**AL/143/24/RES - Approval of reserved matters following outline consent AL/129/21/OUT for 95 No residential dwellings with associated parking, landscaping, open space (including play areas), infrastructure and works. This application is in CIL Zone 3 and is CIL Liable as new dwellings.**

I am writing with reference to the above reserved matters application to advise that Aldingbourne Parish Council objects as it has previously on AL/129/21/OUT on the basis that the Aldingbourne Neighbourhood Plan (ANP) policies as listed below have still not been met:-

Housing Mix Plan - Phase 1	
Project:	Udenny Road Woodgate
Client(s):	BDW Southampton
Drawg No:	ST-22-04
Rev:	E
Scale:	1:500 @ A0
Date:	23/07/2024
Drawn By:	SW
Checked By:	-

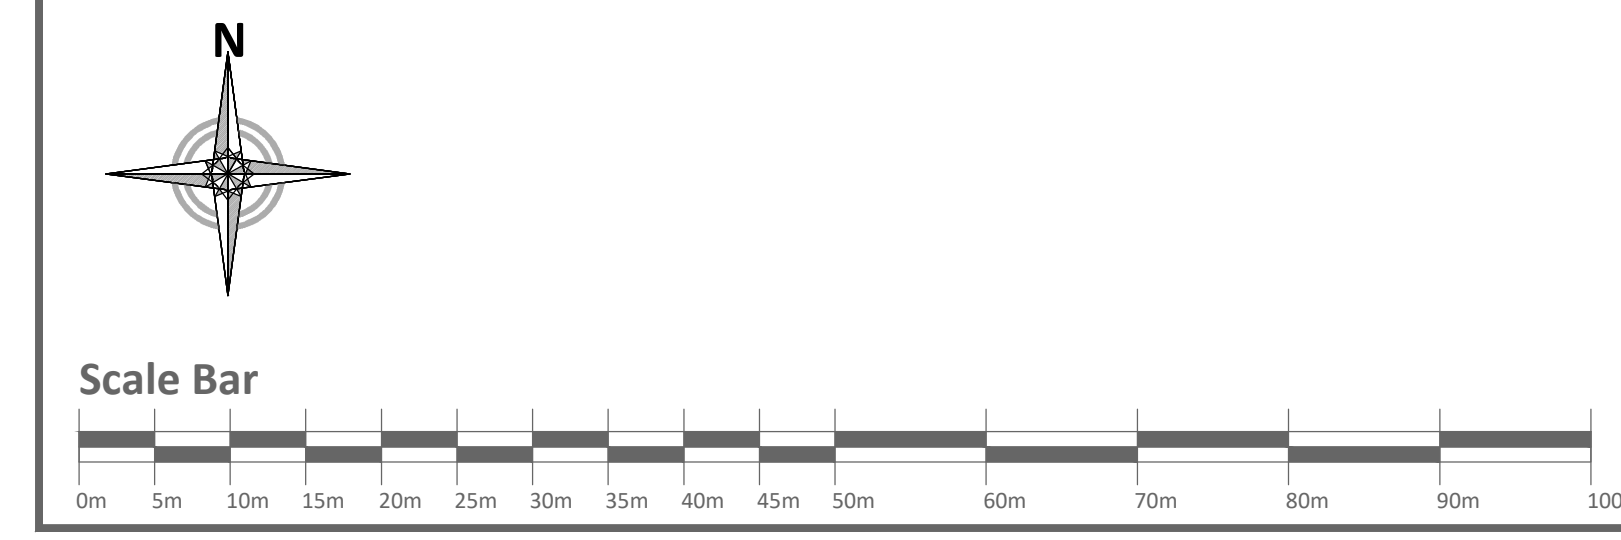
There has been no consultation with the Community Land Trust on the provision of affordable housing with a view to reserving some homes on the site for local people. Aldingbourne Parish Council supports the inclusion of affordable housing but is concerned that plots 77-82 particularly are overlooking bungalows and are in contravention of EH1 (iii) that the development should be sensitively designed.
